20 May 2019

Re: Notice of Exhibition of the Lane Cove West Data Centre (SSD 9741)

ATSYD2_SSD_DRG_ARC_0050

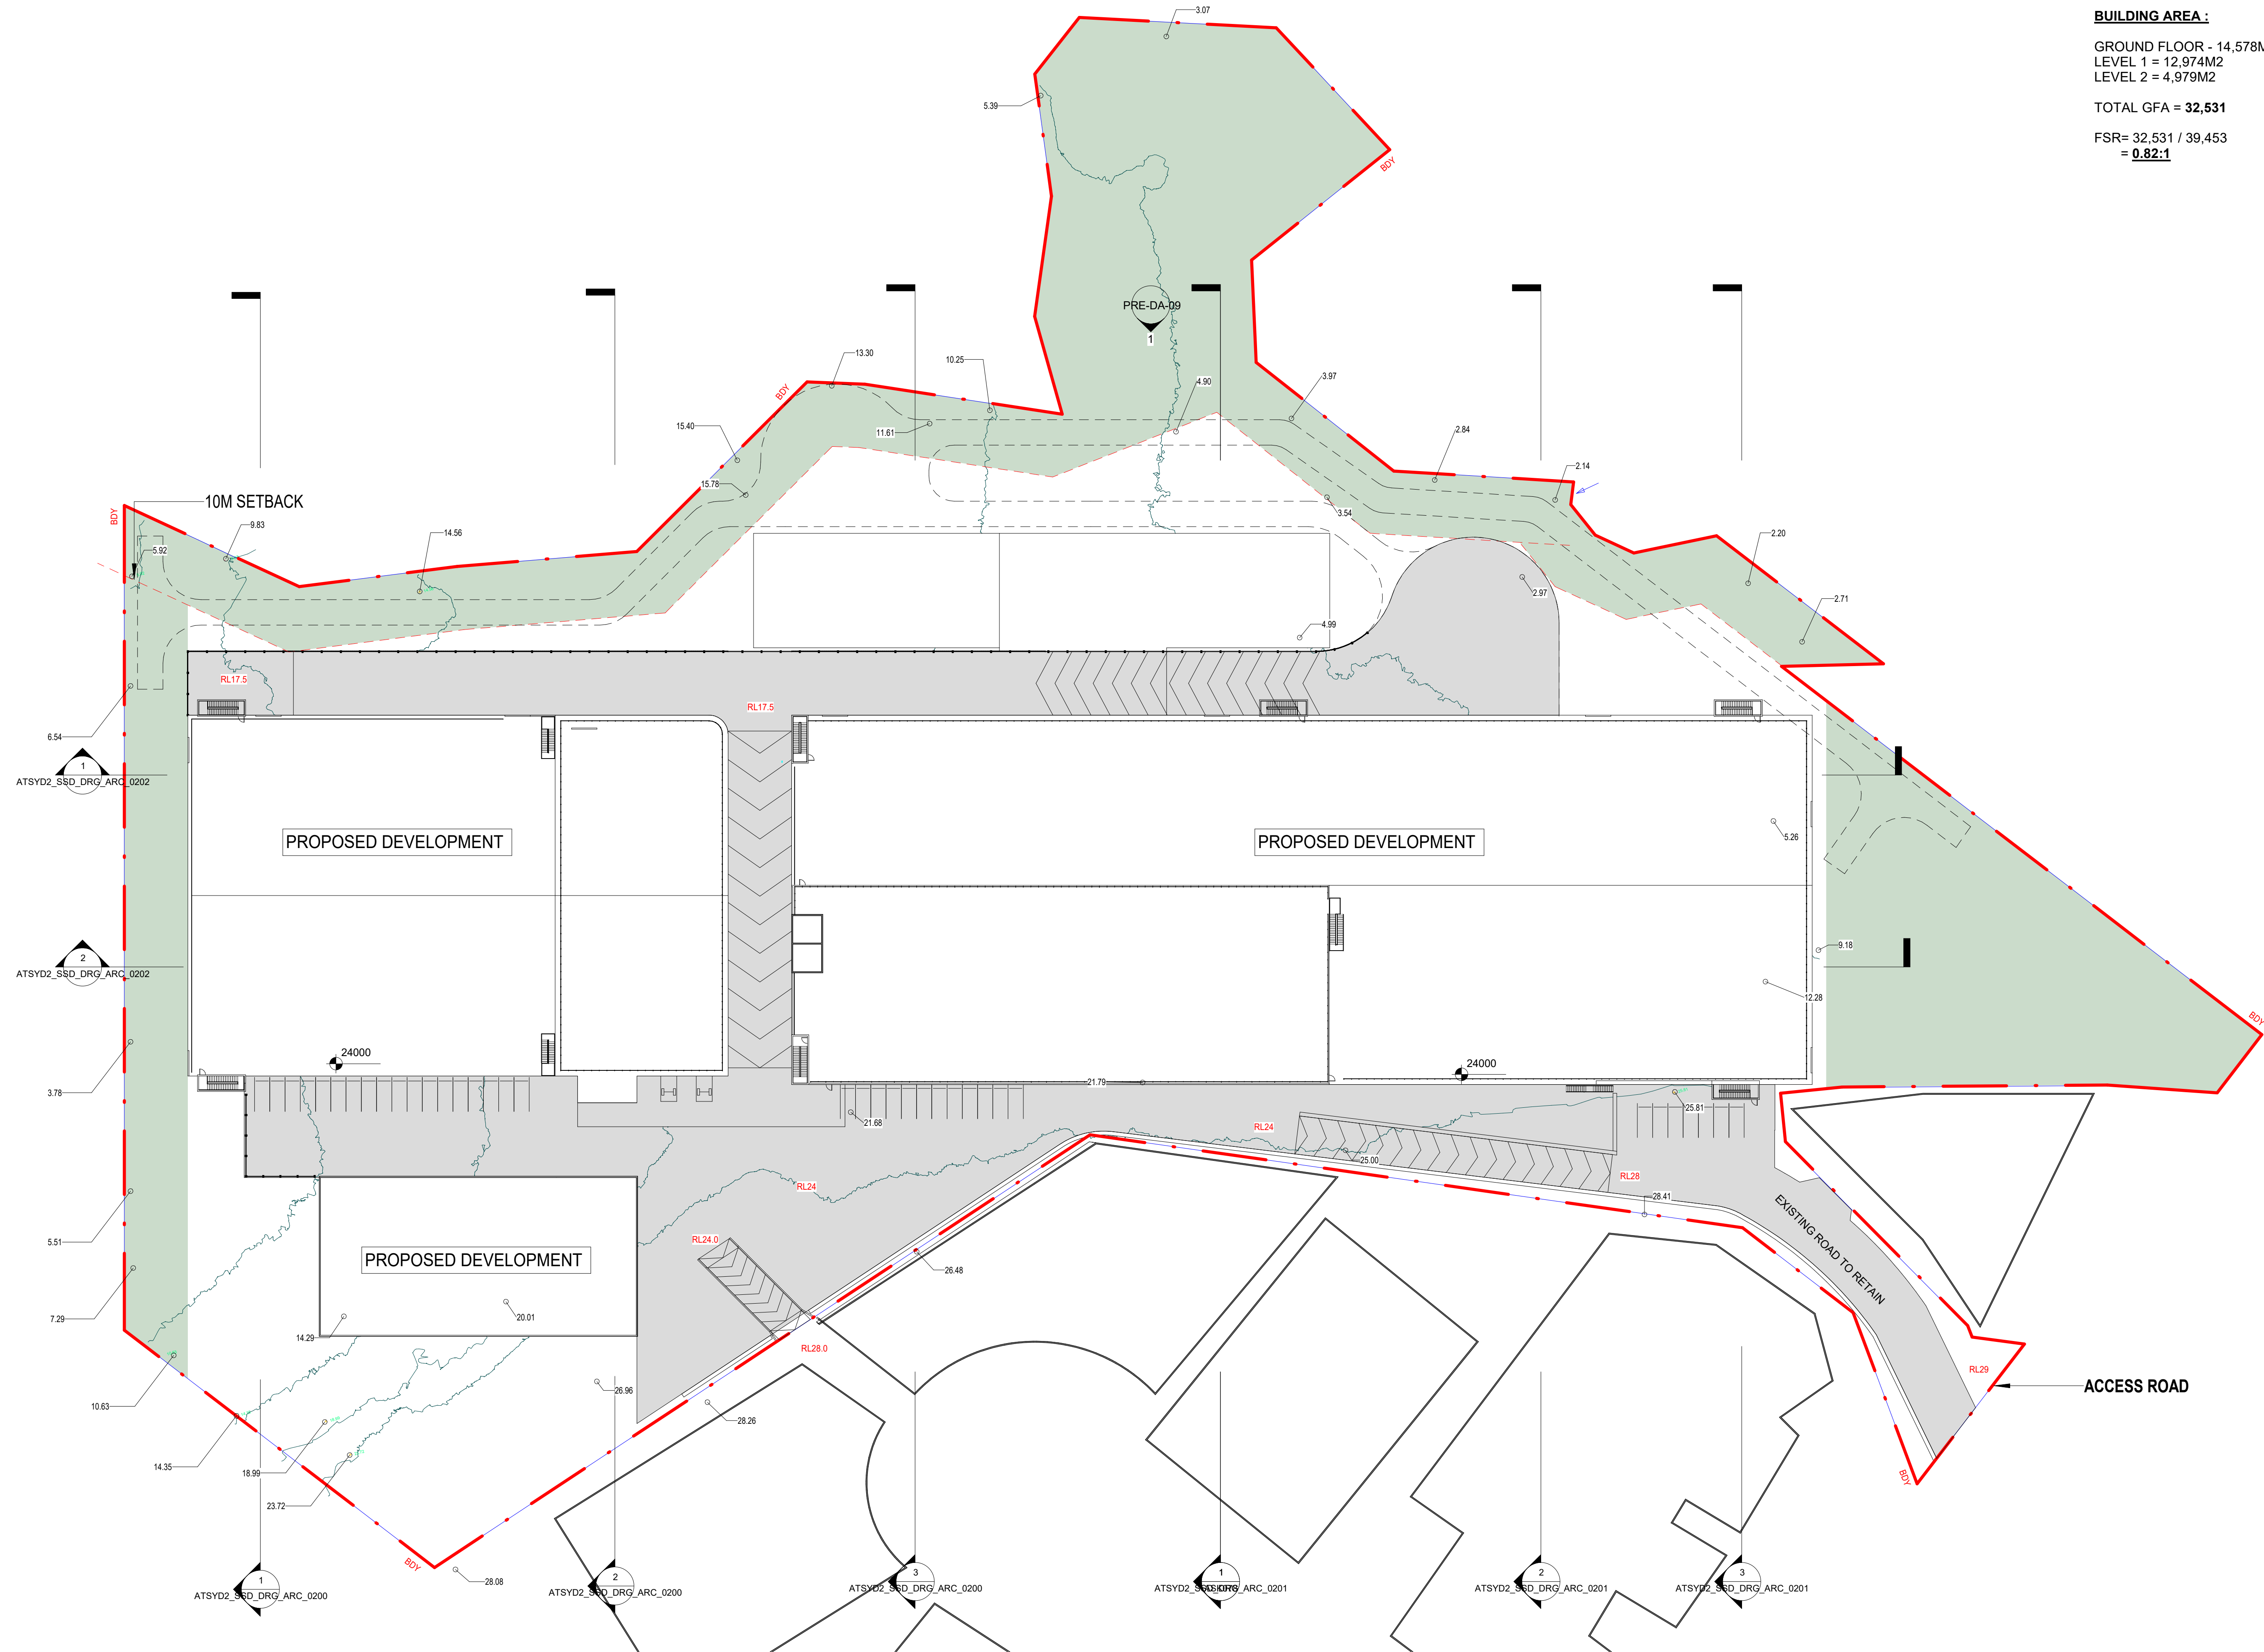
Ausgrid recommends that the conditions of consent include a requirement for consultation with Ausgrid to establish a right of way in the proposed development for access to Ausgrid's easement (DP641935) at the rear of the block. The right of way is to be compliant with the relevant Ausgrid network standards.

An earthing assessment and appropriate design of the proposed boundary fence that traverses Ausgrid's Transmission Line easement is also required. If the fence is of metallic construction, it must be earthed to AS/NZ standards.
